Item No.	Report of the Head of Planning and Enforcement	
Address	2 LINKSWAY NORTHWOOD	
Development:	Part two storey, part first floor side extension, single storey rear extension, conversion of double garage to habitable use, installation of canopy to front and raising of roof to allow conversion of roof space to habitable use to include 3 rear dormers, 1 front dormer and 2 new gable end windows to front (Part Retrospective) (Resubmission)	
LBH Ref Nos:	36910/APP/2016/4594	
Drawing Nos:	A203 - As-Built Plans & Elevations - Rev B(1) A202 - Approved Plans & Elevations - Rev A A201 - Pre-Existing Plans & Elevations A102 - Proposed Block Plan A101 - Location Plan	
Date Plans Received:	21/12/2016	Date(s) of Amendment(s):
Date Application Valid:	21/12/2016

The current application seeks to regularise alterations in the design, scale and footprint of the extended dwelling in its 'as built' form, which differ from that which was approved under 36910/APP/2015/621.

| Cad File    | Sheet Size   | Scale       |
|-------------|--------------|-------------|
| 1440        | A203         | E           |

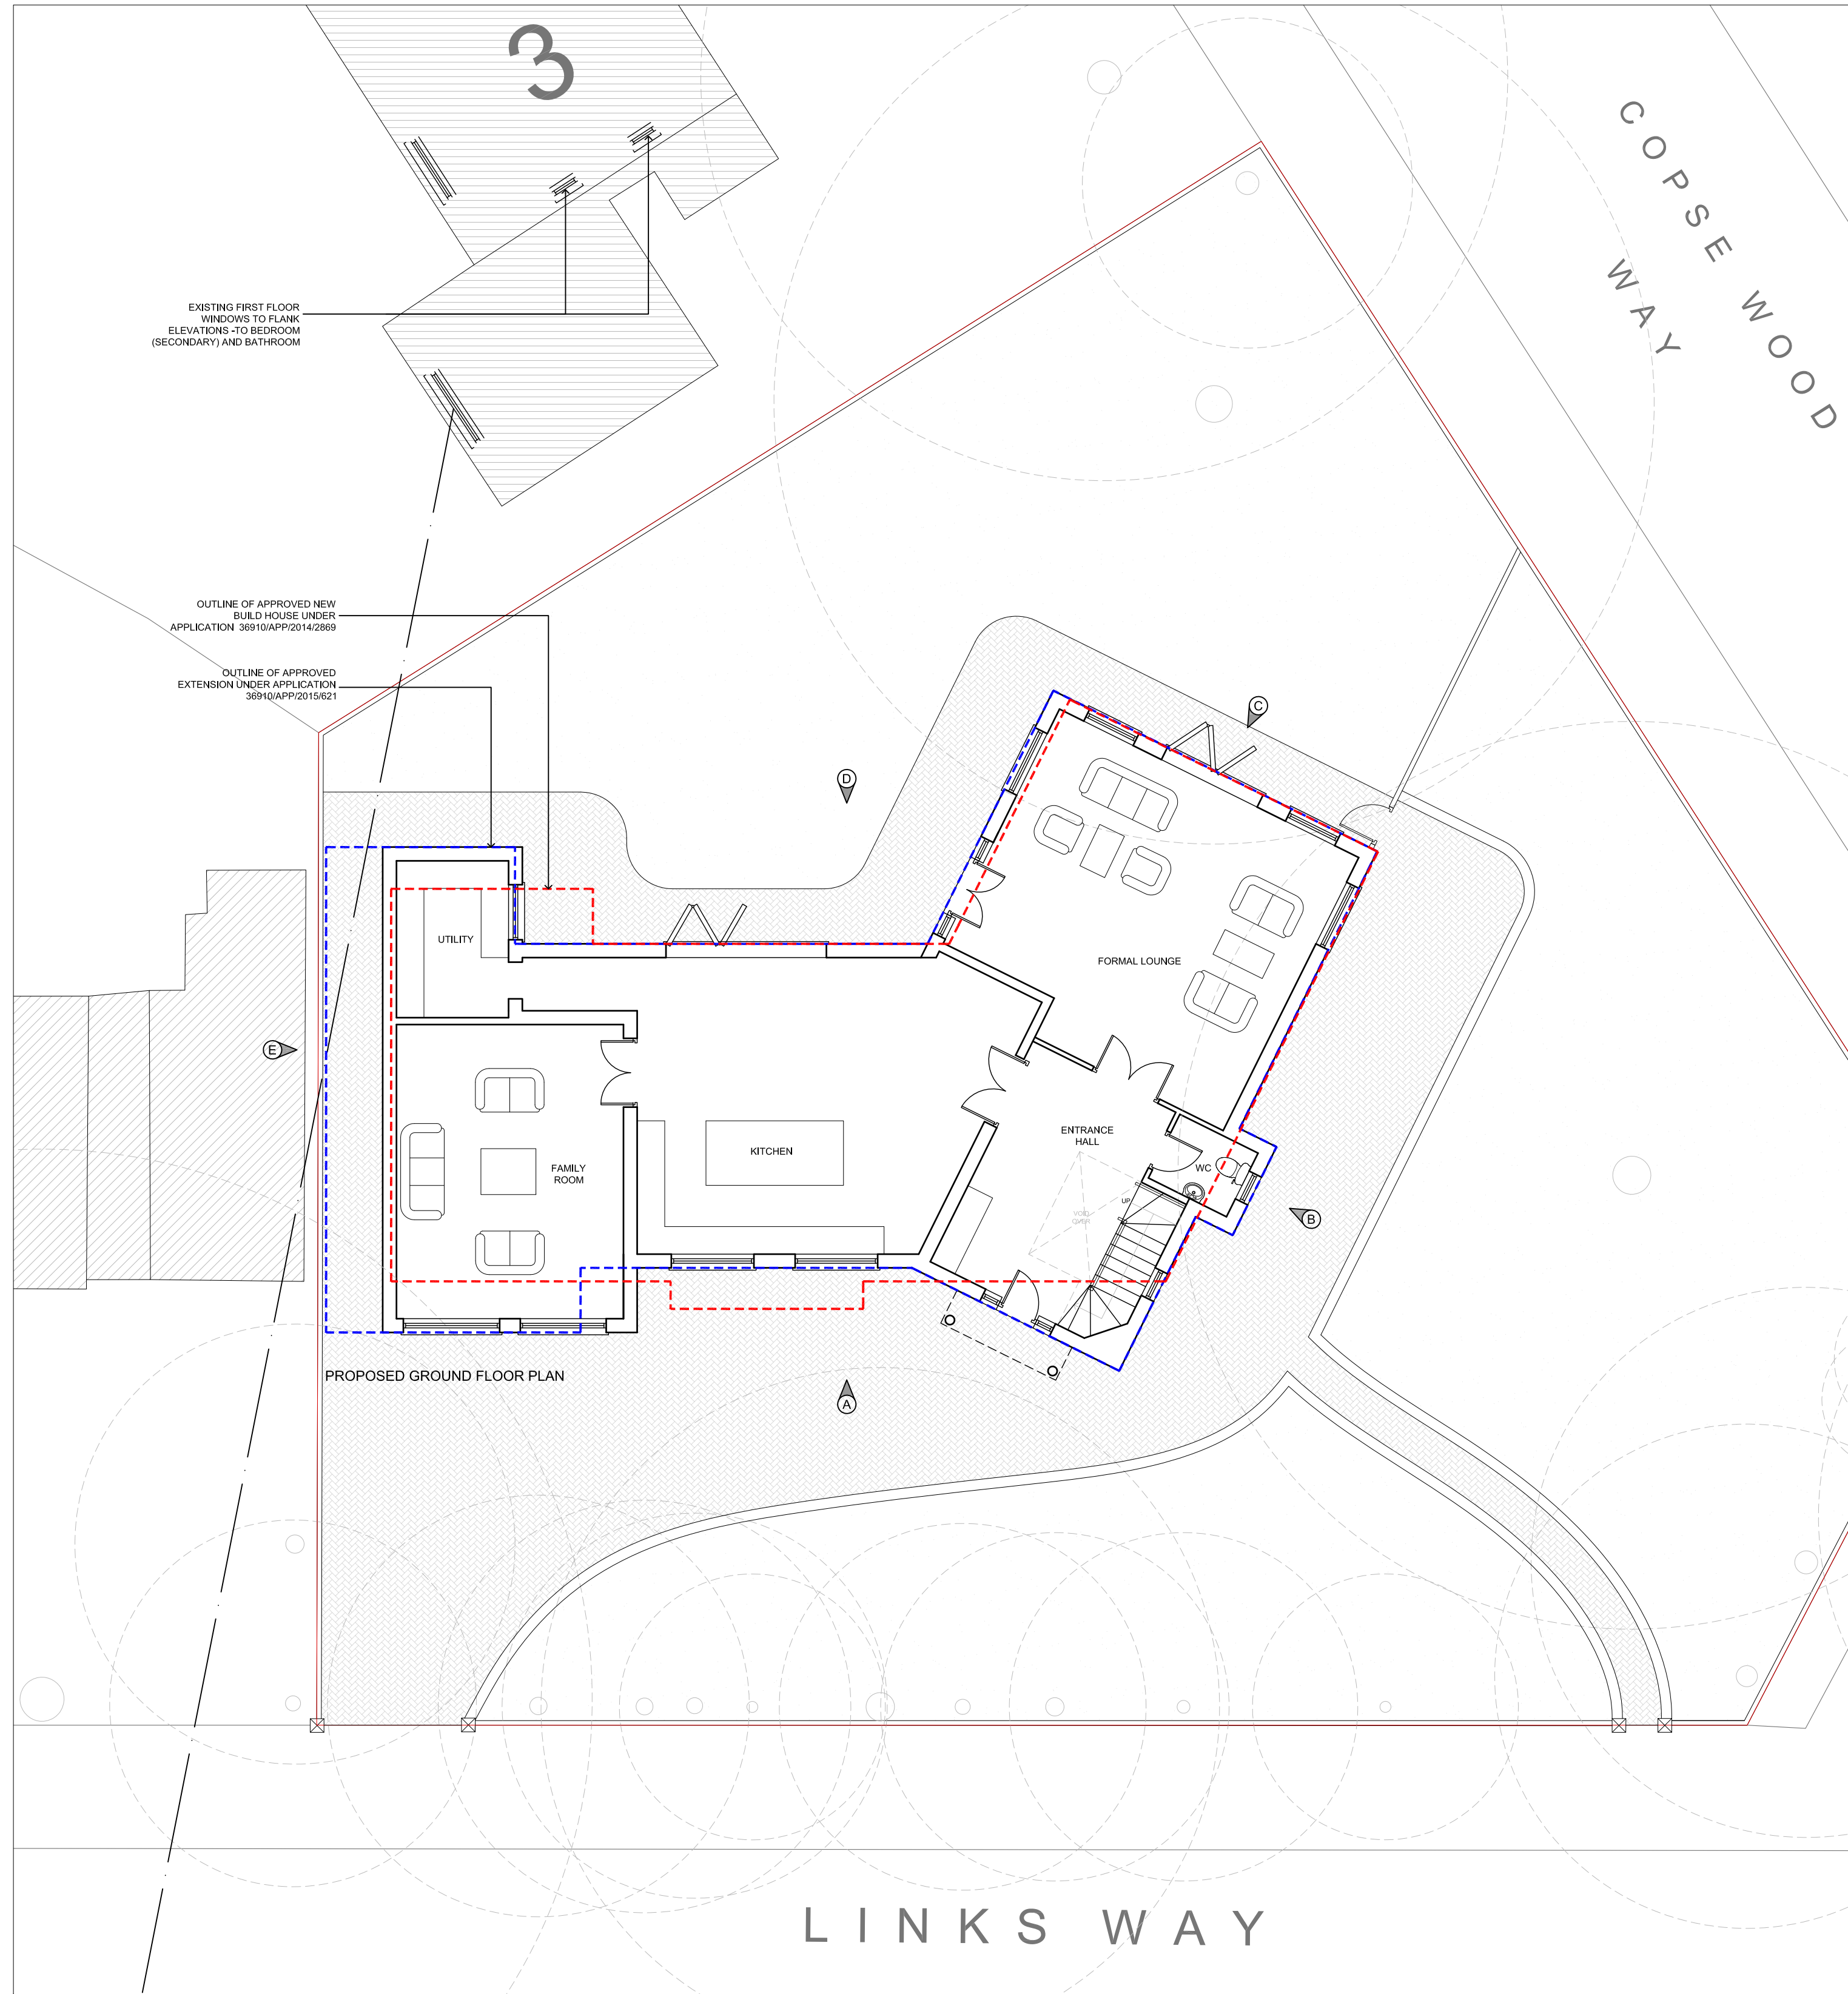
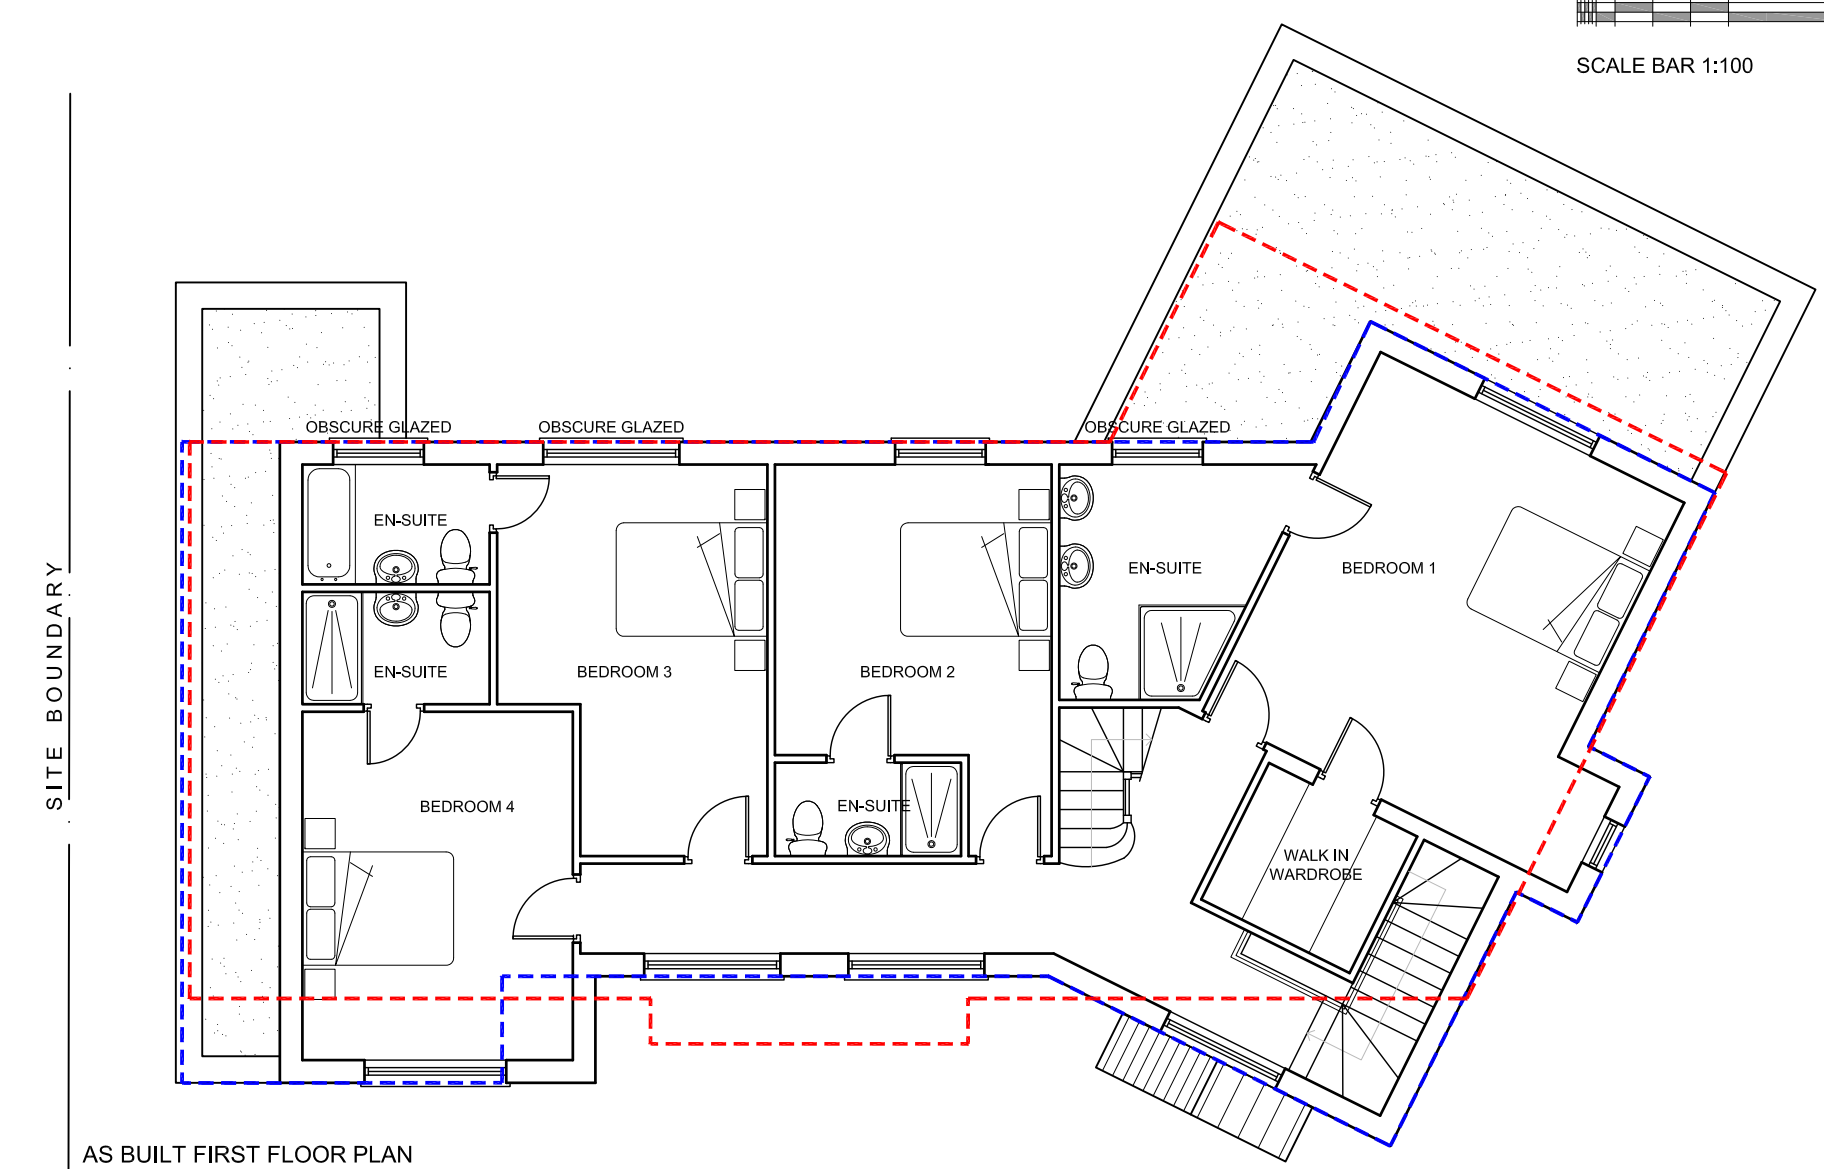
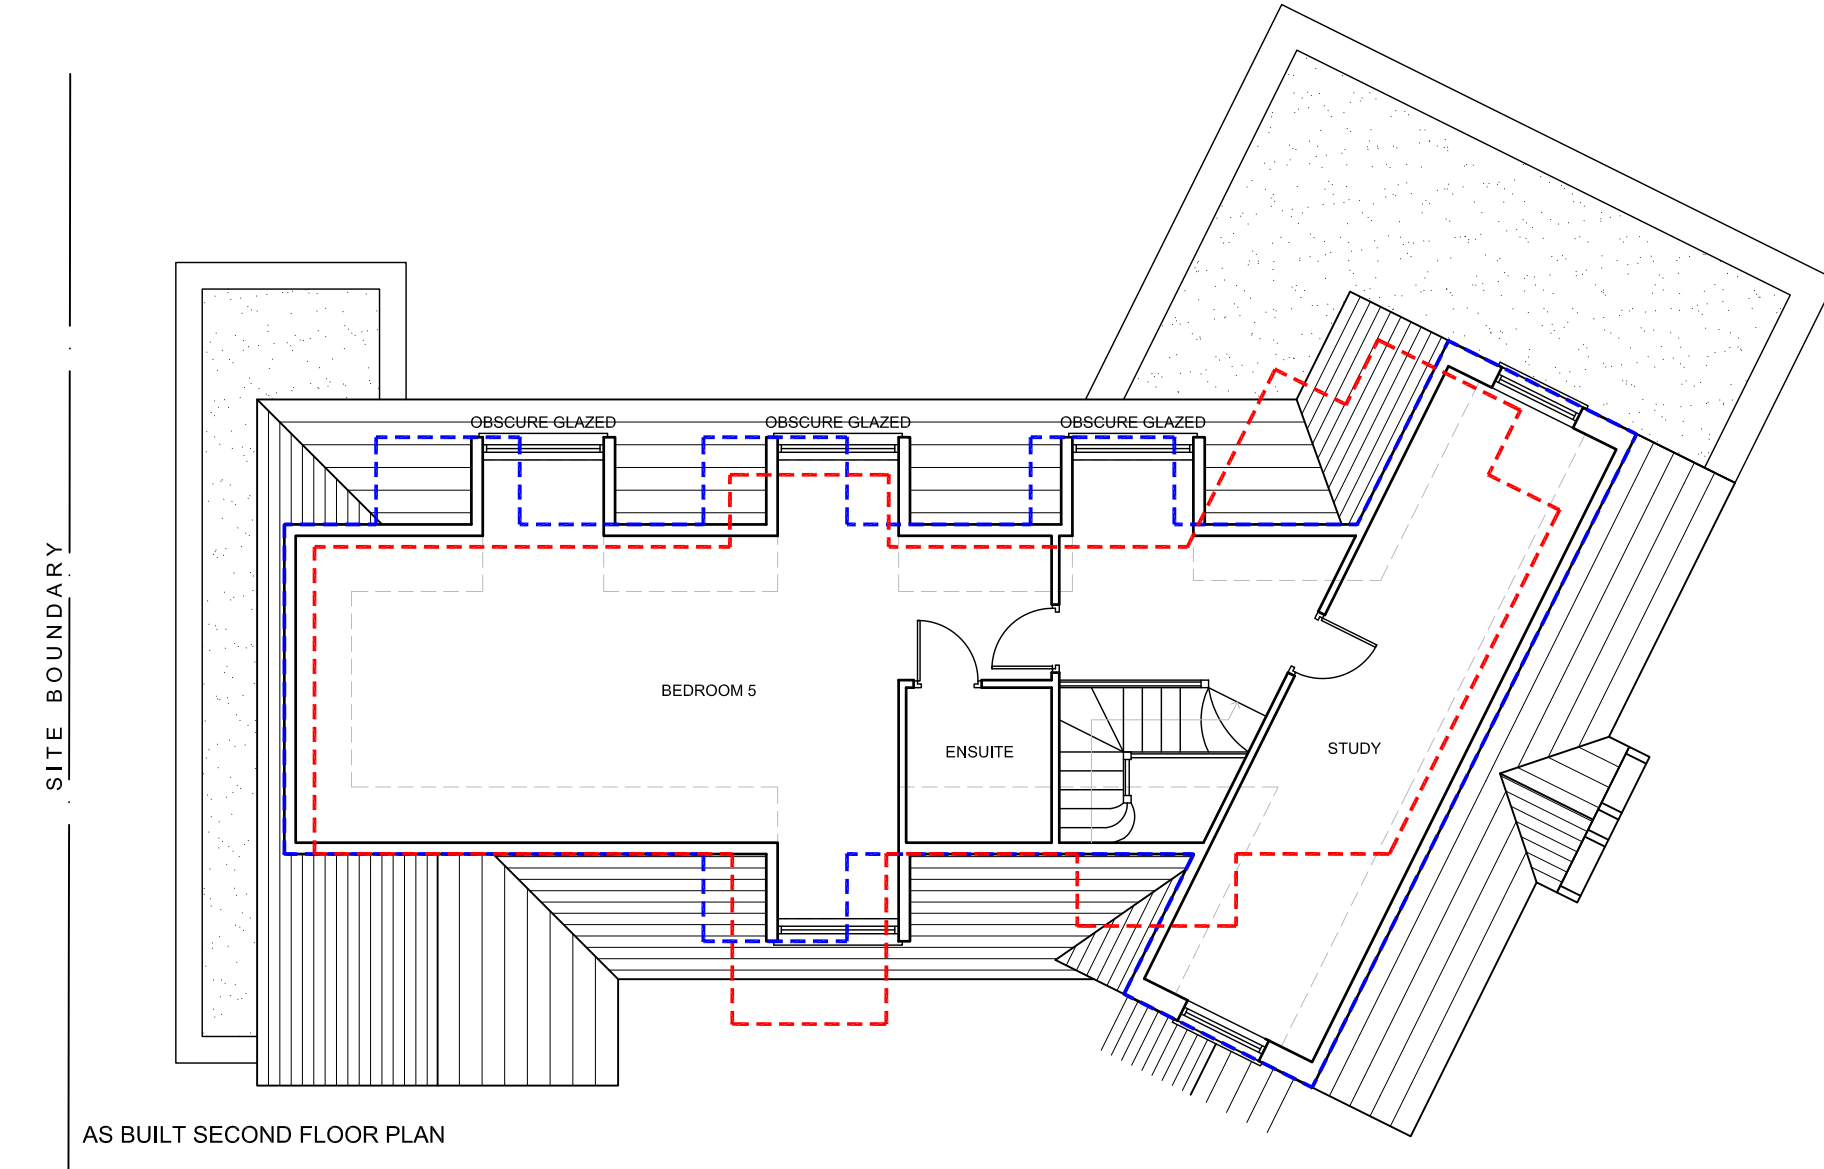
The 'as built' structure exceeds the height permitted by the approved application with the ridge height being increased by 0.335 metres and the eaves height being more substantially increased by 0.8 metres. By raising the eaves, the 'as built' dwelling has vertical walls of an increased height which appear significantly more prominent than in the approved permission. As a result, the building elevations appear more stark and visually prominent and it is considered that this is unacceptable given the visual sensitivity of the site and its surrounds and due to the fact that the previously approved development was

considered to be at the maximum scale appropriate for the plot. Furthermore, the approved application had the eaves directly above first floor windows, which is a common characteristic of buildings on Linksway including the host dwelling, the increased eaves height has left a gap between the top of first floor windows and the eaves which is not consistent with this distinguishing feature within the surrounding area. It is therefore considered that the development does not satisfy the requirements of Local Plan policies BE 5, BE 6, BE 13 and OE 1 and policies 7.4 and 7.6 of the London Plan.

The increase in the height of the eaves is not matched by an increase in ridge height and this has resulted in a roof form that is shallower than that which was approved. As a result, the proportions of the building have been altered which, again, has resulted in a more prominent and overly dominant structure. The decrease in roof size has also resulted in the prominence of the various dormer windows being exaggerated to a degree that they are less sympathetic towards the form of the building as a whole.

The unacceptable scale and massing of the development now built is further emphasised by the disproportionate increase in the height of the single storey additions to the side and rear. These have increased by 0.5 metres and now extend close to the cill level of the enlarged first floor windows. The result of such, is that the proportions of the building appear visually at odds with the scale and form of the host building and dominate the ground floor to an unacceptable degree. These also make these additions more prominent in view from surrounding properties/street scene and result in the elevations appearing cramped and contrived in form.

considered that these windows would compromise the privacy of neighbouring residents due to the orientation of the windows relative to those within No. 3 Copse Wood Way. Further, a number of the windows at first and second floor served en-suite bathrooms and were therefore to be obscurely glazed. The reconfiguration of the internal layout of the building has resulted in habitable rooms now being served by windows in a similar position to where obscure glazed windows serving bathrooms and storage space were originally approved. The previous application was refused, in part, due to the potential overlooking of the garden space at 3 Copse Way that would be offered by windows serving these re-positioned rooms. The applicant has sought to address this concern by applying an obscure film to the windows concerned and restricting the opening angle of the windows. It is considered that obscure glazing adequately addresses the overlooking concerns but that a more permanent means of obscure glazing should be used. A condition can be attached to any approval given to require obscure glazing to be permanently maintained. The current arrangements for restricting the opening of the windows is insufficiently robust and lacks permanence. In order to secure privacy the windows should be fixed shut with ventilation provided only by fanlight openings set a minimum of 1.8 metres above internal floor level. A condition could also be attached requiring this change to be made.

The second floor bedroom is served by a front facing window that does not require obscure glazing and it is therefore considered that adequate natural light and outlook would be available to this room. The window serving bedroom 2 (as referred on the accompanying plan A203 Rev C) at first floor level has not been obscurely glazed. However, this window was approved with clear glazing under 36910/APP/2015/621 and it does not offer overly intrusive views towards 3 Copse Way due to its orientation and modest size. The window serving bedroom 3 on the same floor has been partially obscure glazed as the outlook is towards a secondary bedroom window and the wider garden area. It is considered that this obscure glazing is therefore necessary in order to comply with Local Plan Policy BE 24 but that it presents a significant barrier to natural light penetration within the bedroom which is not served by any other windows and also present a poor outlook. It is therefore considered that the living conditions within the room are not of an acceptable level for it to be used as a bedroom. The development is therefore considered to conflict with Policy BE 20 of the Local Plan and para. 4.9 of the Residential Layouts SPD.

Overall, the alterations are considered to result in a development that would appear unduly dominant and overbearing when viewed from the neighbours garden at No. 3 Copse Wood Way and from the wider public domain. It is considered that the current application of obscure glazing does not fully address overlooking concerns given that the windows can still be opened, however, it is considered that this can be overcome by way of applying a planning condition if approval is granted. Furthermore, it is considered that the use of obscure glazing in bedroom 3 has resulted in unacceptable living conditions

The resultant scale and massing of the 'as built' extensions are considered to dominate the prominent corner setting to an unacceptable degree. The alterations would detract from, and fail to harmonise with, the character, form and modest scale of development within the surrounding street scene and Area of Special Local Character to the detriment of the building's appearance and setting. The scheme would thereby be contrary to Policies 7.4 and 7.6 of the London Plan, policy BE1 of the Hillingdon Local Plan: Part One - Strategic Policies, BE5, BE13 and BE19 of the Hillingdon Local Plan - Saved policies and HDAS 'Residential Extensions'.

The 'as built' alterations to the extension by reason of the proximity, siting, size of the windows and internal are considered to overlook the private garden of No. 3 Copse Wood Way to an unacceptable degree, to the detriment of these occupiers. The proposed obscure film applied to the overlooking windows and the ability for those windows to be opened are not considered to provide a sufficiently permanent or robust means of mitigating the overlooking of the neighbouring rear garden. The application would thereby erode the privacy and living conditions of these occupants to an unacceptable degree. Further, the increase in the height of the extensions would result in a scheme that would appear unduly dominant and visually overbearing to the detriment of the amenities of No. 3 Copse Wood Way. The application therefore fails to comply with the NPPF, Policies BE21 and BE24 of the Hillingdon Local Plan: Part Two - Saved Policies and HDAS 'Residential Extensions'.

The use of obscure glazing within Bedroom 3 (as identified in accompanying plan A203 Revision C) results in a habitable room in the extended property from receiving sufficient daylight and provides that room with an inadequate outlook, to the detriment of the living conditions of that property and the residential amenity of future occupiers. The application therefore fails to comply with Policy BE20 of the Hillingdon Local Plan - Saved Policies.
